From: Laura Gibbons
Sent: 06 November 2018 13:55
To: Planning.Responses
Cc: David Easton
Subject: RE: Planning Consultation on BE/117/18/DOC

Engineers Comments Regarding Condition 5 and 6

Registered: 05-NOV-18
Site Address: Land off New Barn Lane Bersted PO21 5ED

Description of Works: Application for approval of details reserved by conditions imposed on planning reference BE/18/17/PL relating to condition 5 (Surface water drainage), 6 (SUDs system), 14 (Foul drainage) & 23 (Vehicle access)

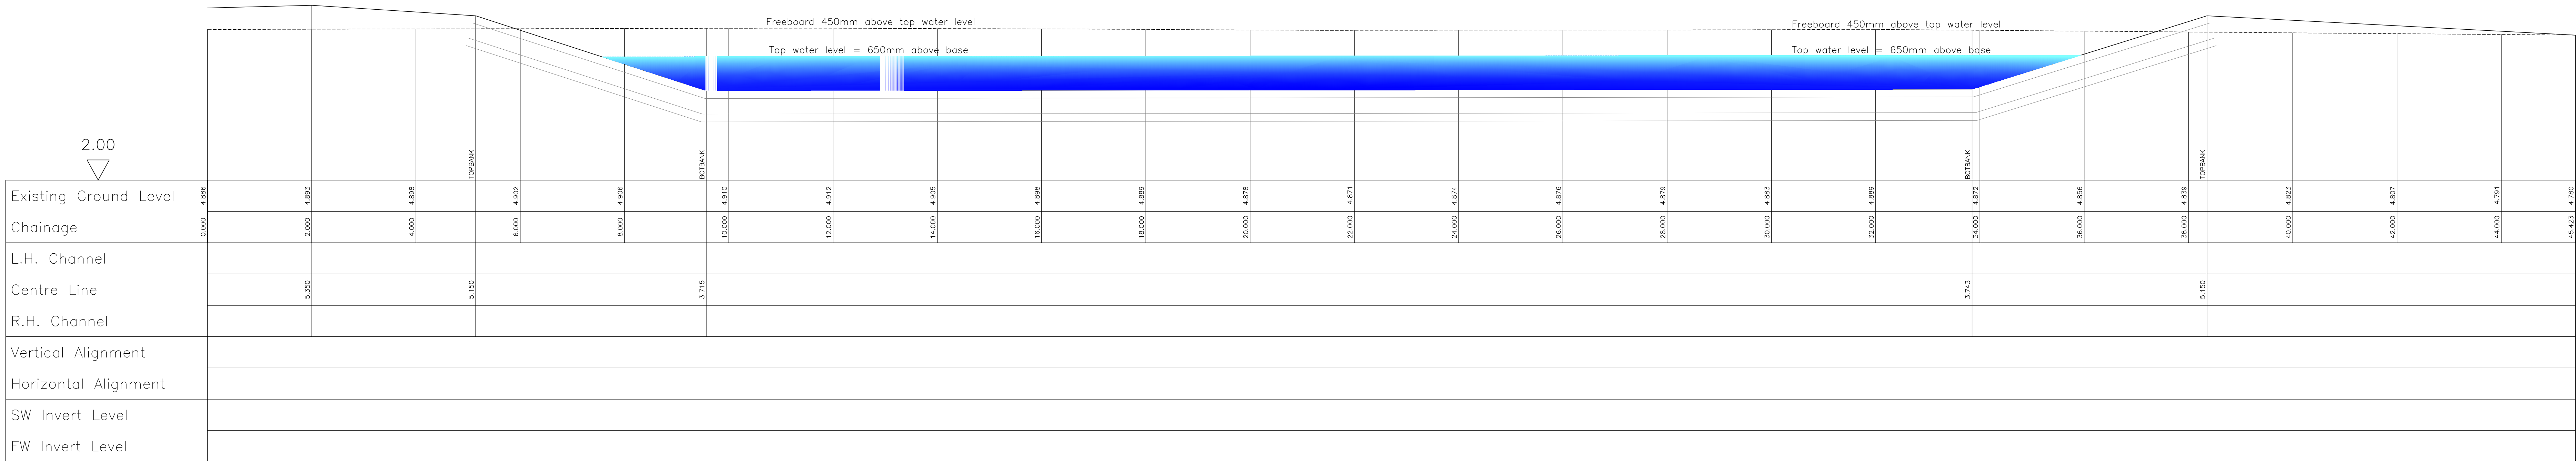
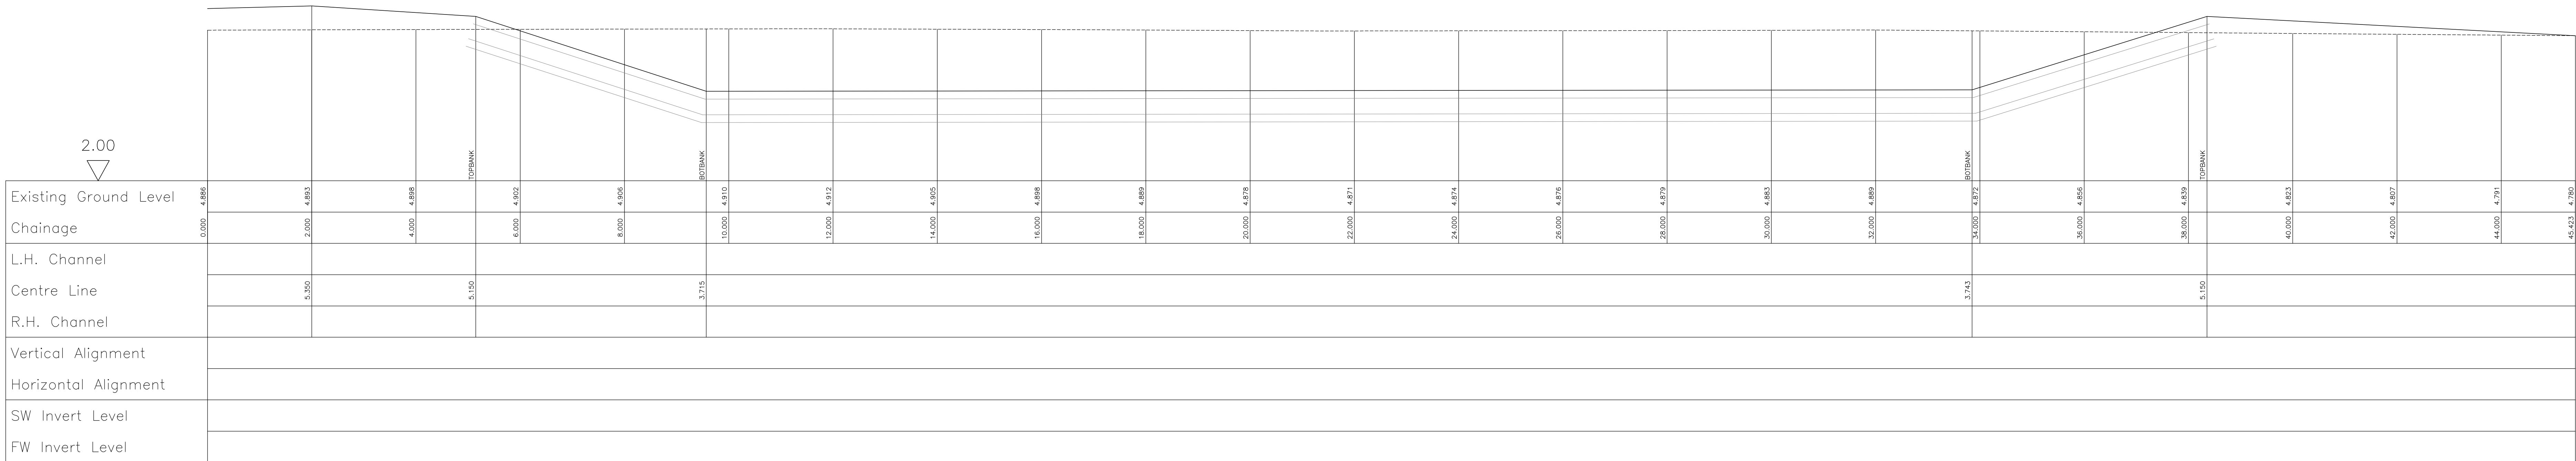
3. No confirmation of if the geotextile specified on the swale/ pond section is permeable or impermeable. And no accompanying confirmation of consideration of groundwater/ flotation. Geomembrane located above stone liner. BENTOMAT A5100 fleece liner below stone. No accompanying calculations.

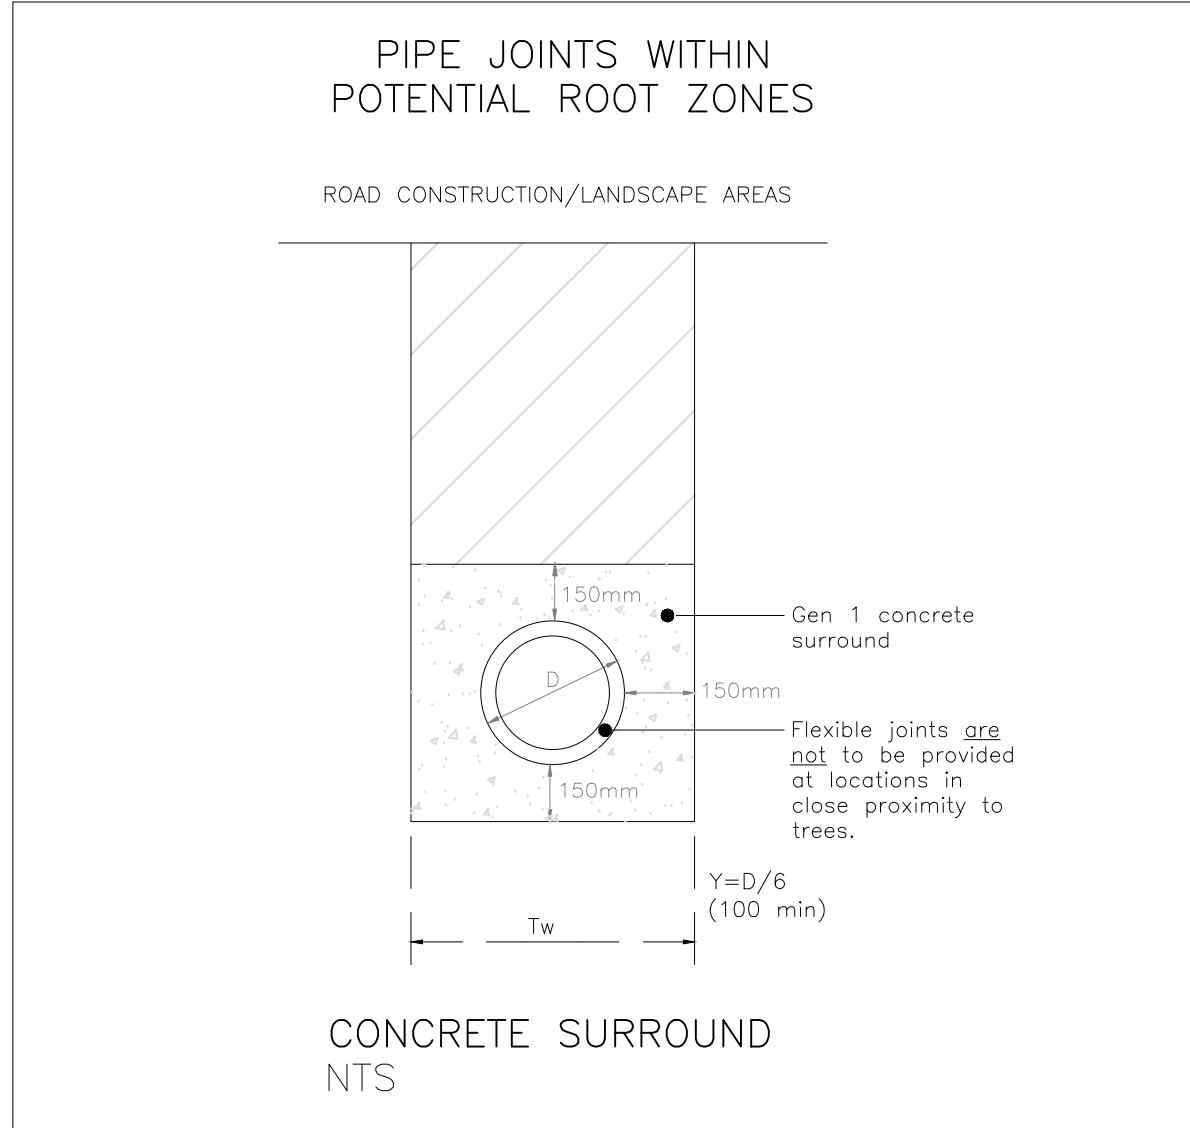
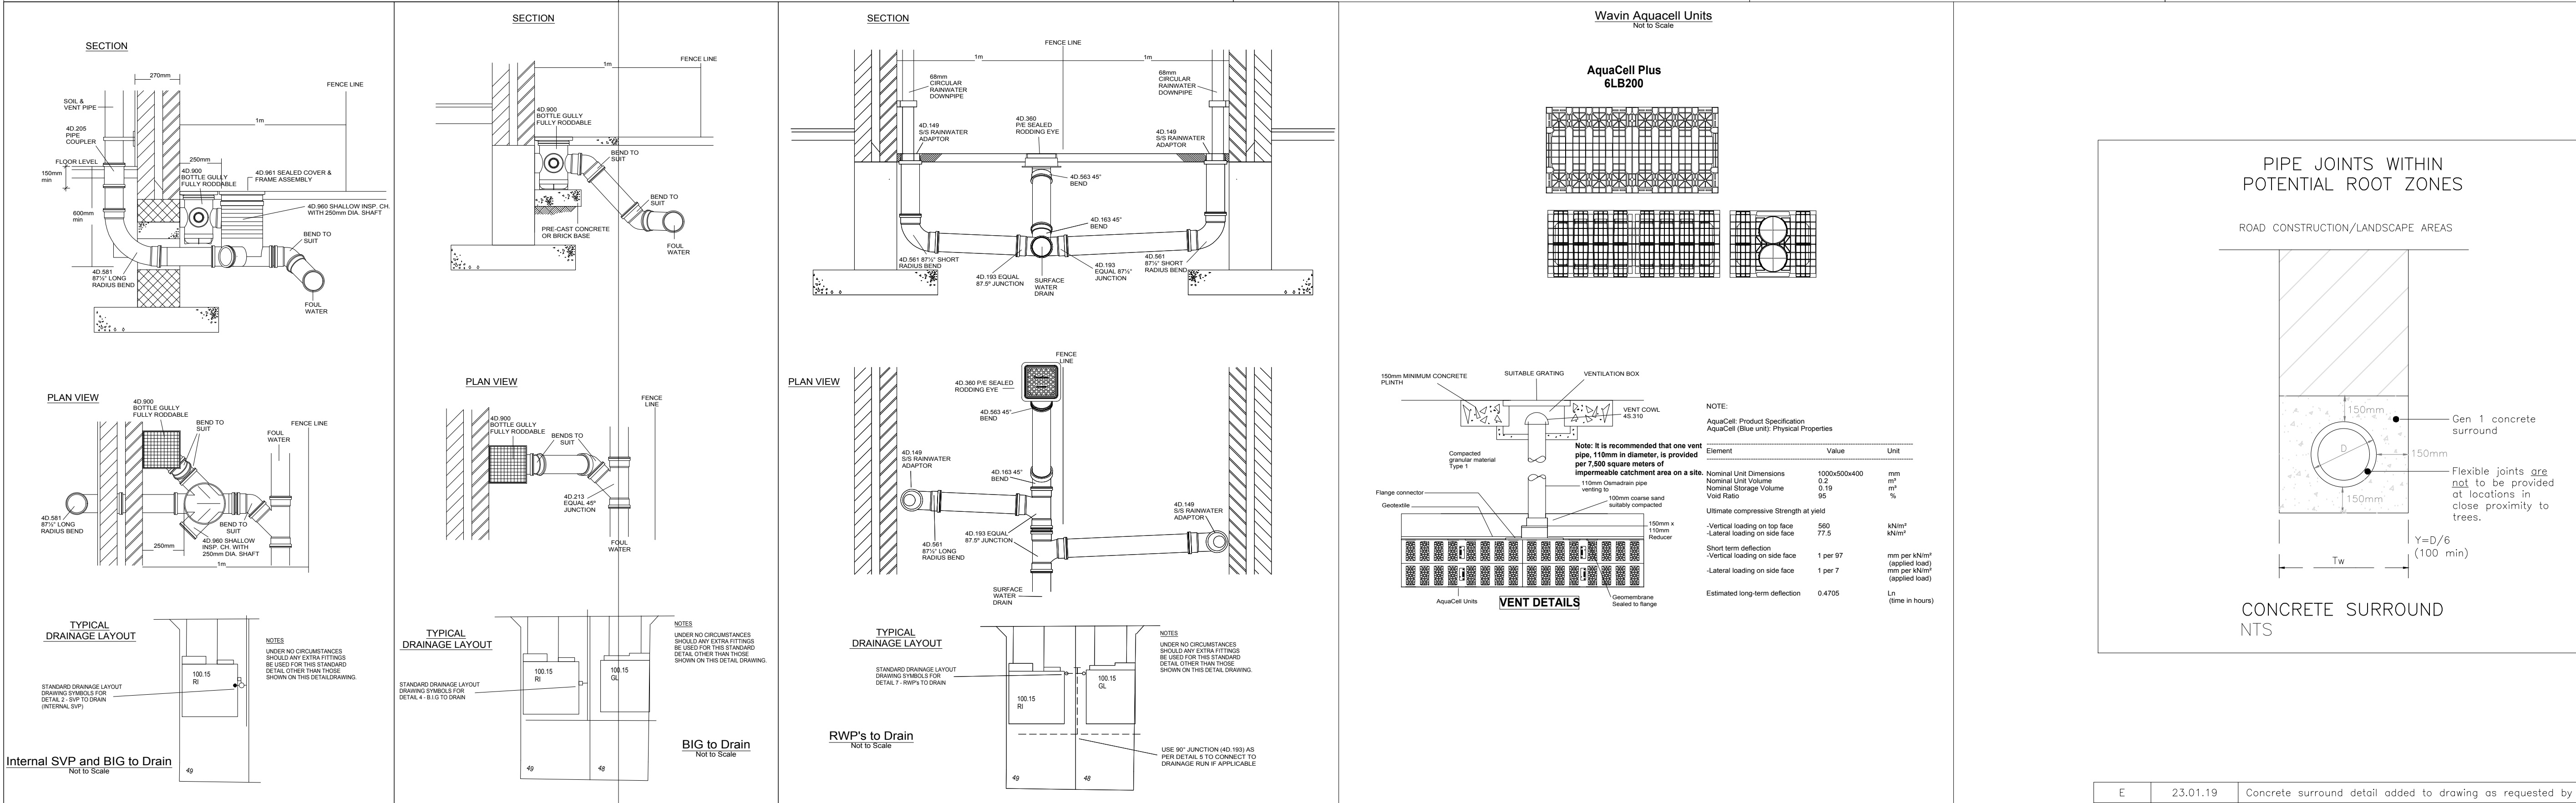
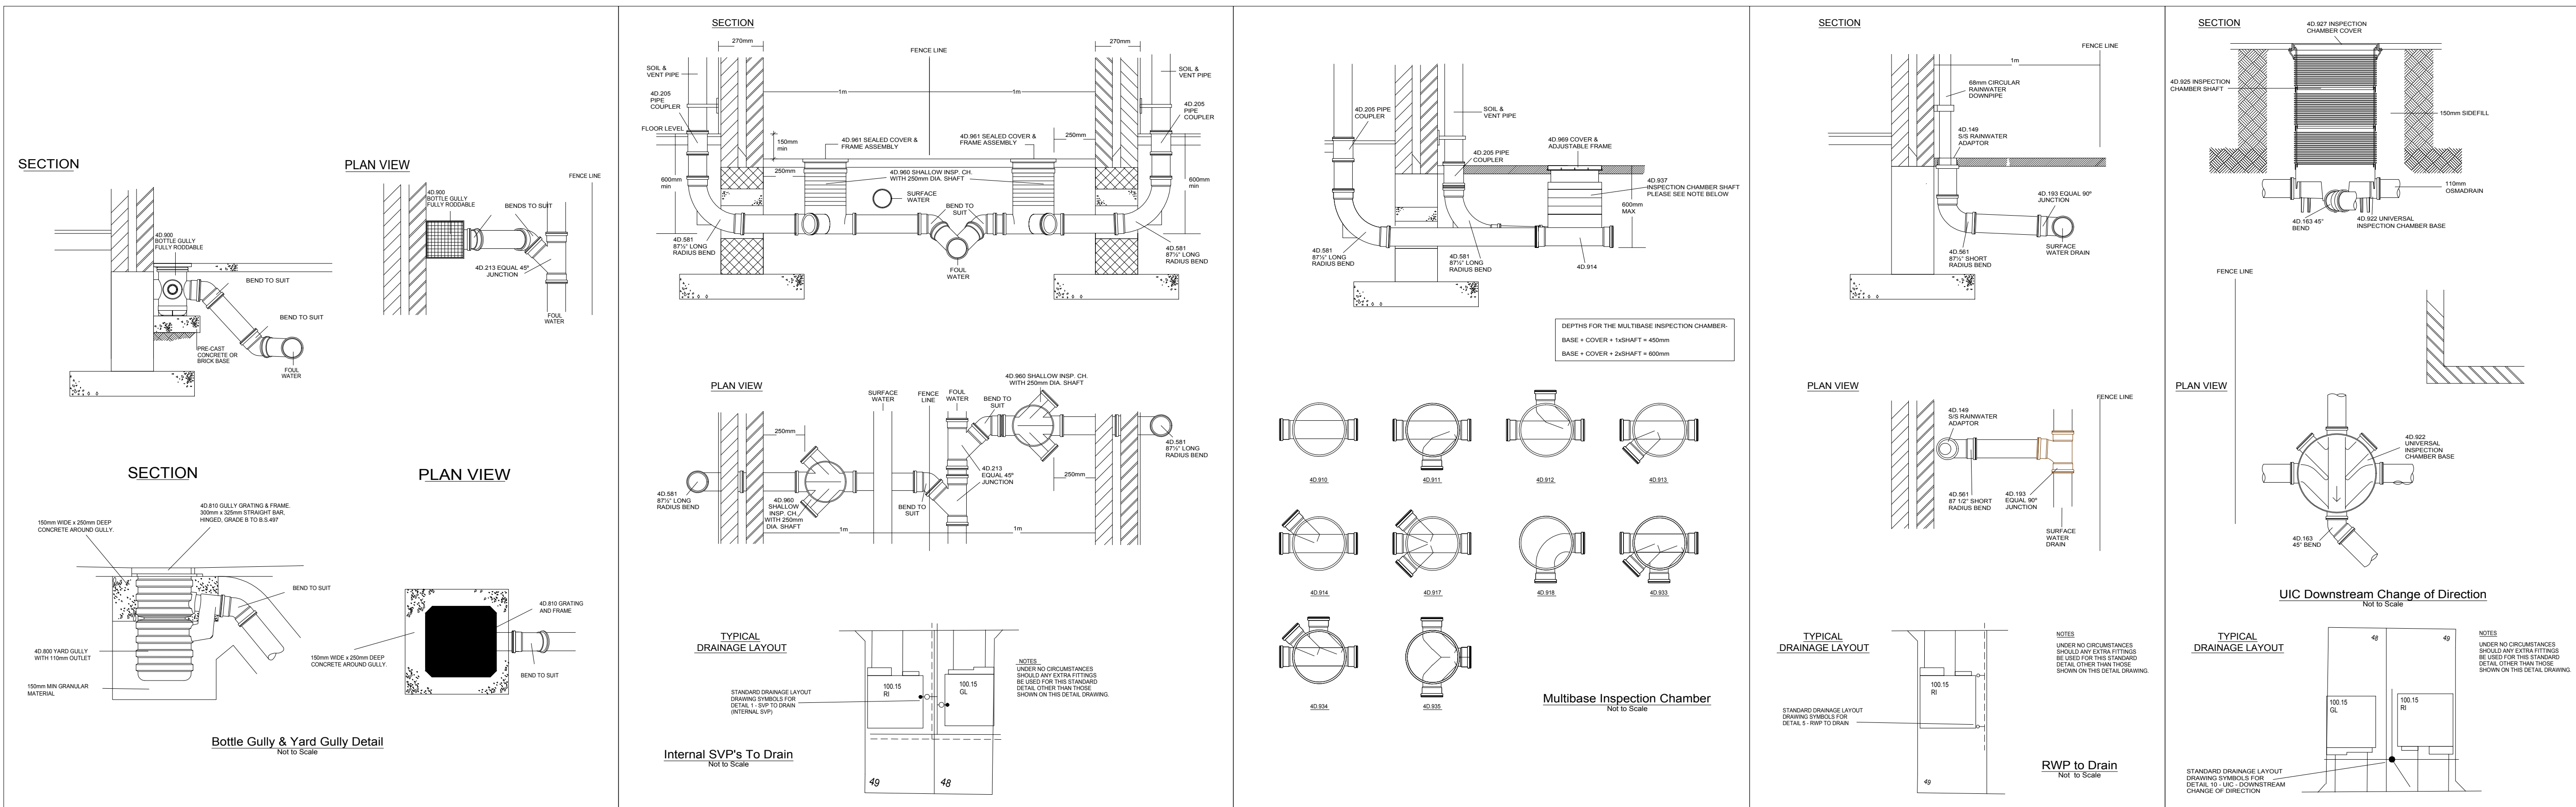
8. Construction details of the storage tanks currently show that they are infiltration not attenuation tanks. Please can the developer/ engineer confirm. Corrected on layout but no revised construction details provided.
